**RE: Caliber Collision – 250 98th ST NW  
Erosion and Sediment Control Plan  
Engineer's Stamp Date 3/7/24 (D17E008)**

Based on the information in your submittal received on 7/19/26, the ESC plan cannot be approved until the following comments have been addressed.

CITY OF ALBUQUERQUE PUBLIC WORKS DIVISION ENGINEERING GROUP	
Caliber Collision EROSION CONTROL DETAILS	
DESIGN REVIEW COMMITTEE	CITY ENGINEER APPROVAL
LAST DESIGN UPDATE	MO./DAY/YR.
	MO./DAY/YR.
	MO./DAY/YR.
	MO./DAY/YR.
SHEET # 25 of 25

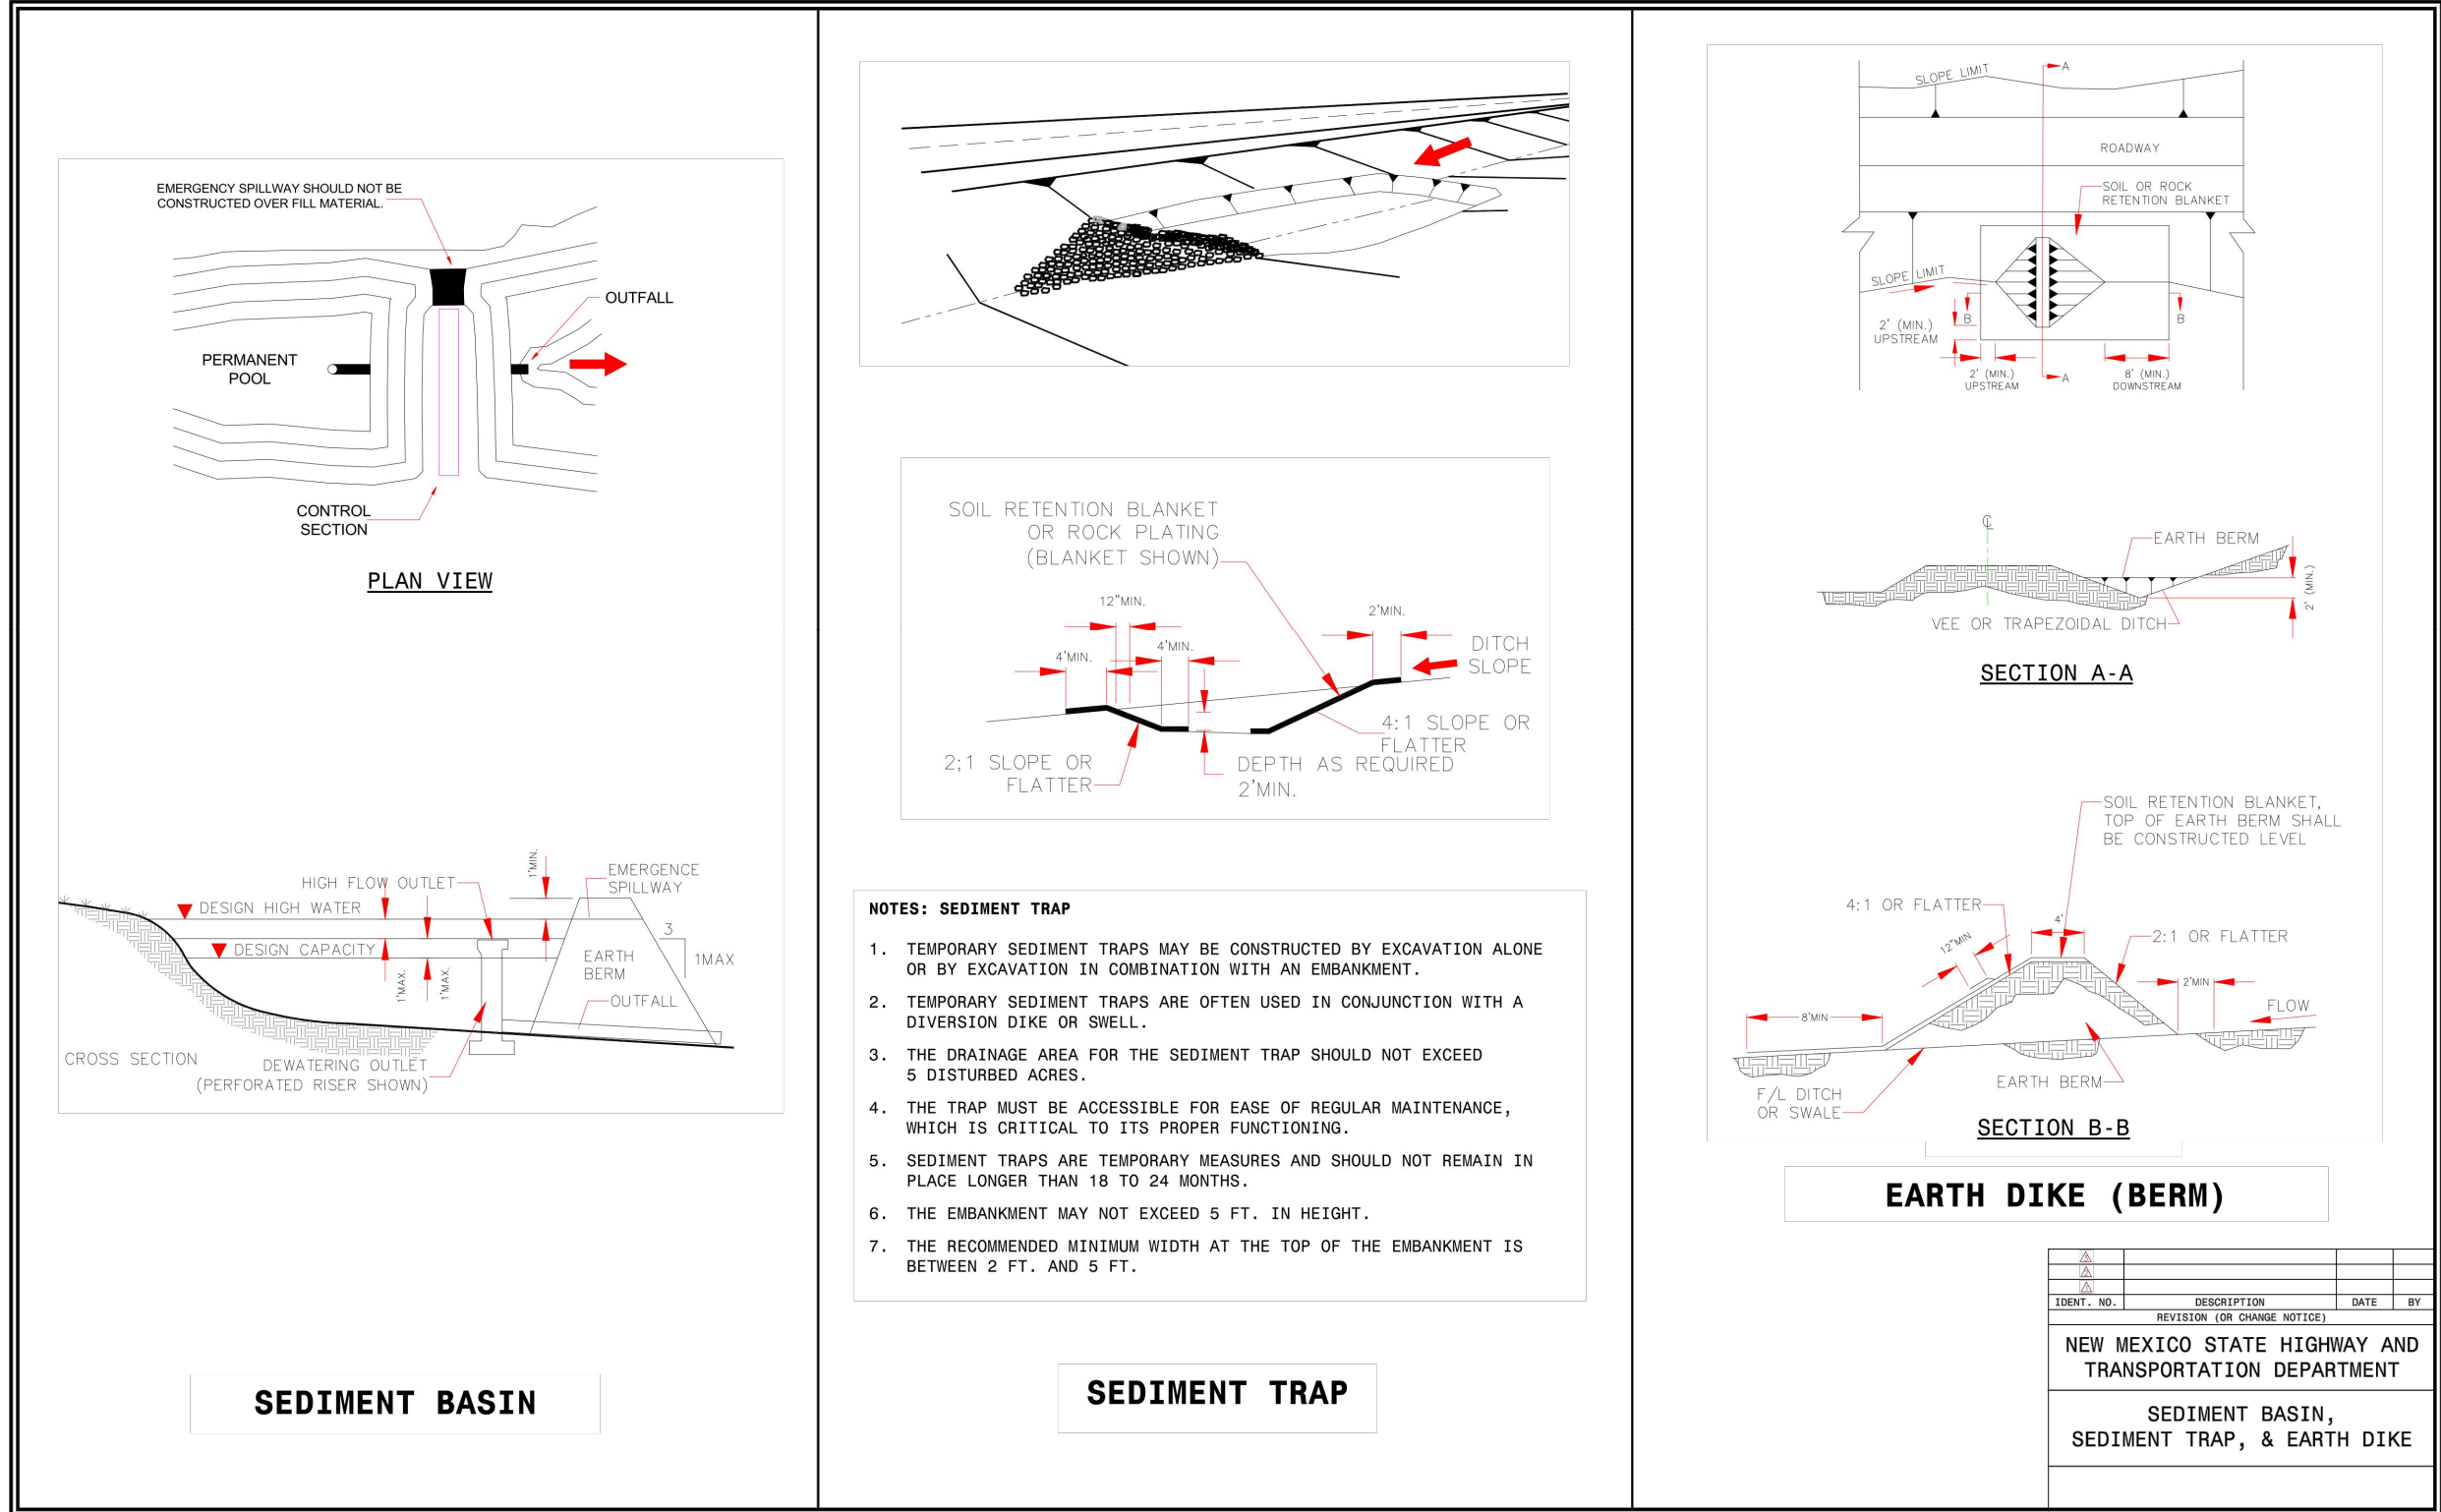
7. The Erosion and Sediment Control ESC Details are missing the construction, inspection, and maintenance specifications, as required by the city' ESC Plan Checklist and by CGP 9.6.1.c.i.
